**Consultation Response from KC,
Trees**

2026/91314 Ash Meadow, East Avenue, Lindley, Huddersfield, HD3 3LW

Erection of detached supported-living dwelling with associated access, parking, landscaping and subdivision of existing residential curtilage (within a Conservation Area)

Date Responded: 21/08/2026

title:
 Proposed Driveway Strategy

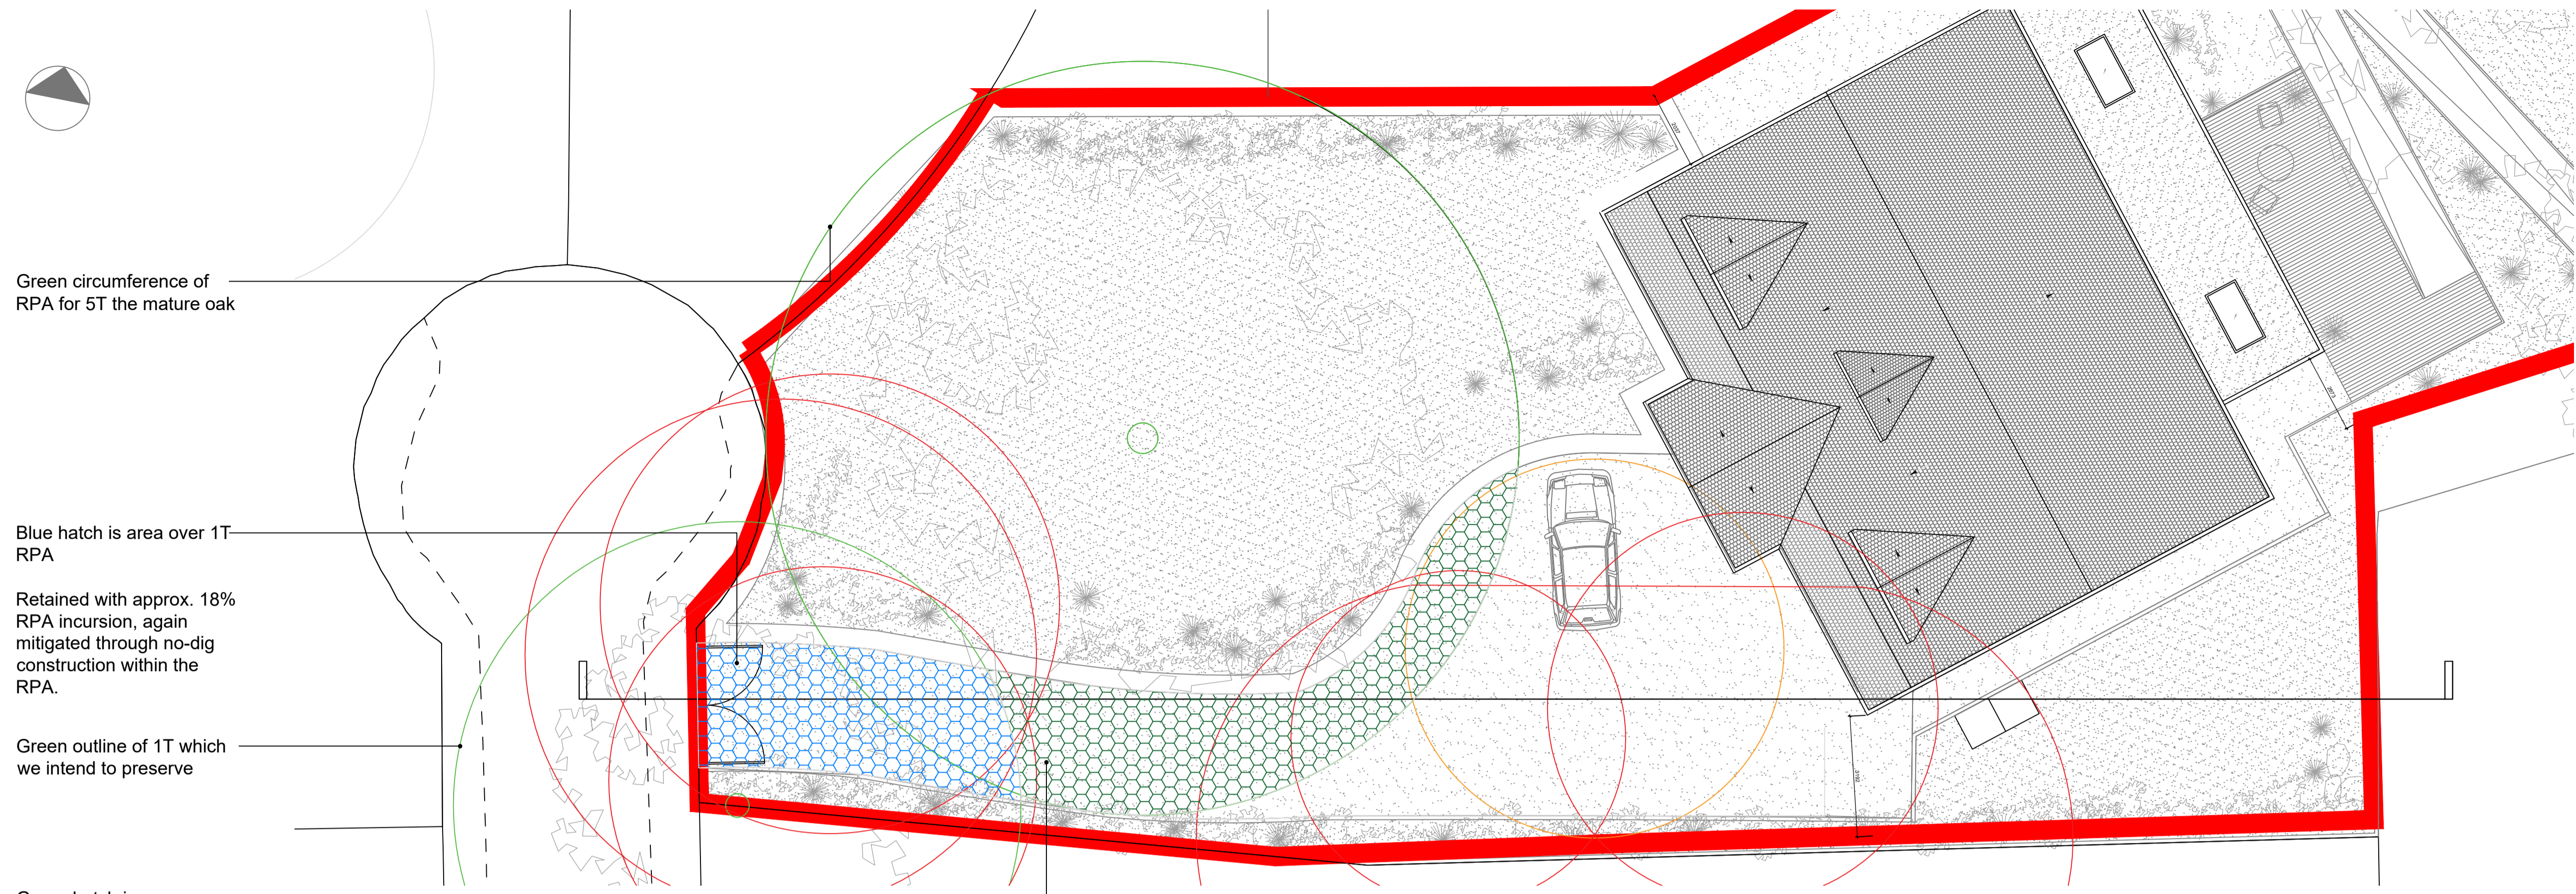
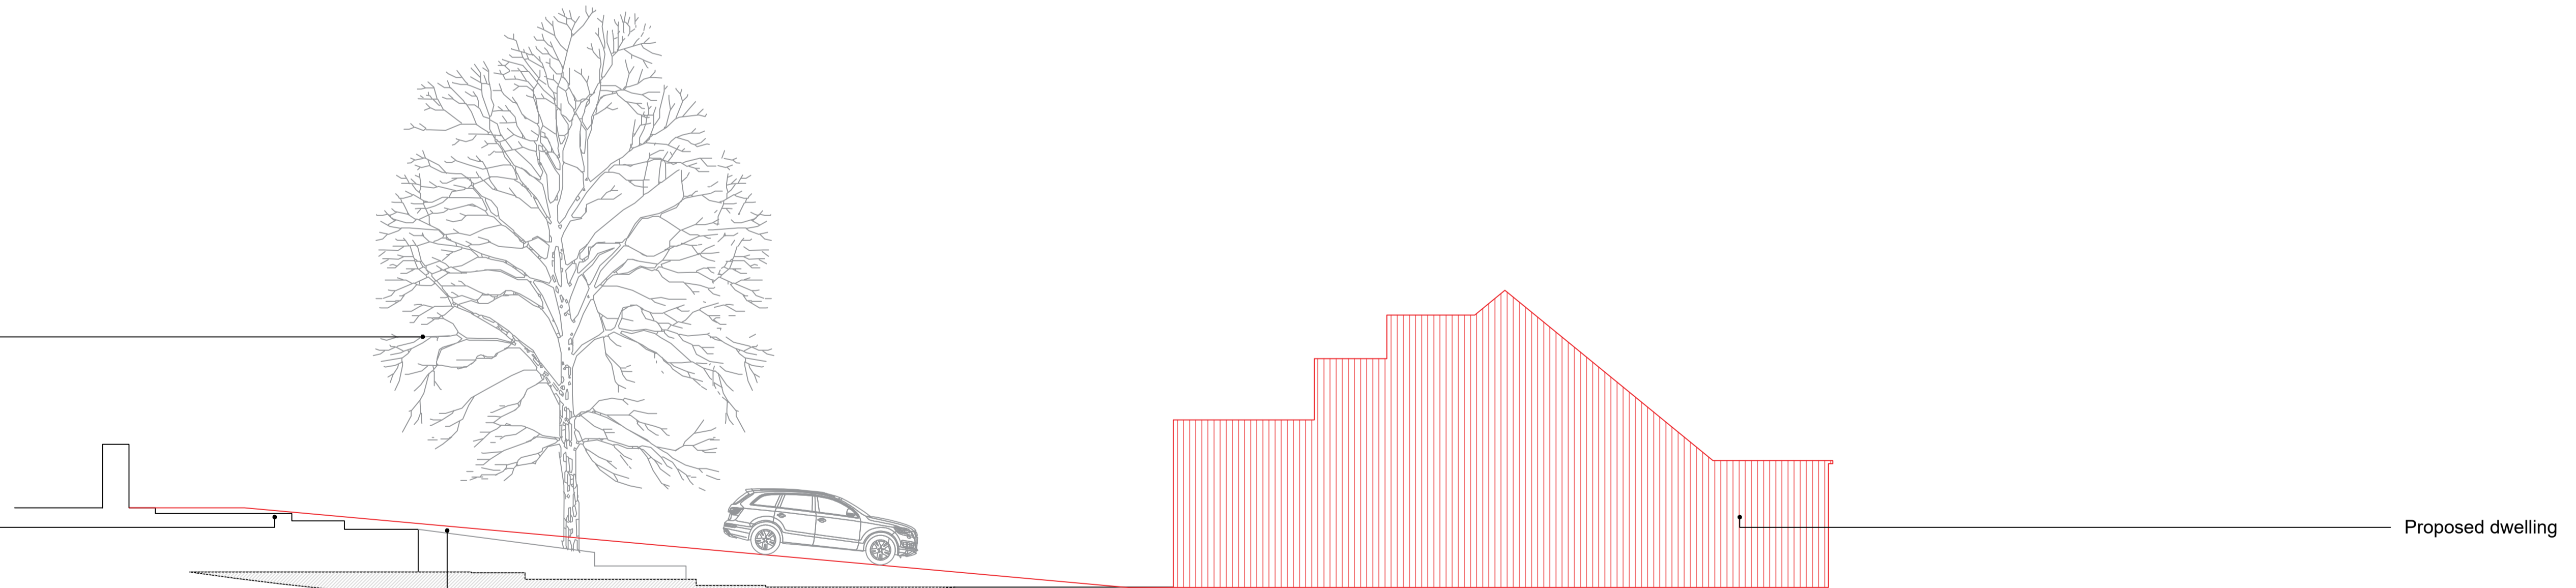
There are 4 individual trees and 2 groups to be removed to facilitate the proposals. 5 of the 6 removals are category B trees which means they are of higher value and should be retained where possible and should only be considered for removal if there is sufficient justification. There is also a significant level of planned works within RPA's of retained trees. Whilst sensitive design options have been proposed within RPA's there is still likely to be an impact which only increases the overall Impact to the site.

There are also other concerns of indirect impact such as shading, dropping of seasonal detritus and falling branches. The proposed building is situated to the North of 22T which means it will likely be cast in shade most of the day. The shedding of leaves, dead branches and excessive shading are some of the leading causes for works to protected trees applications. Therefore the pressure to have these protected trees pruned or even removed is likely to increase as a result of the development.
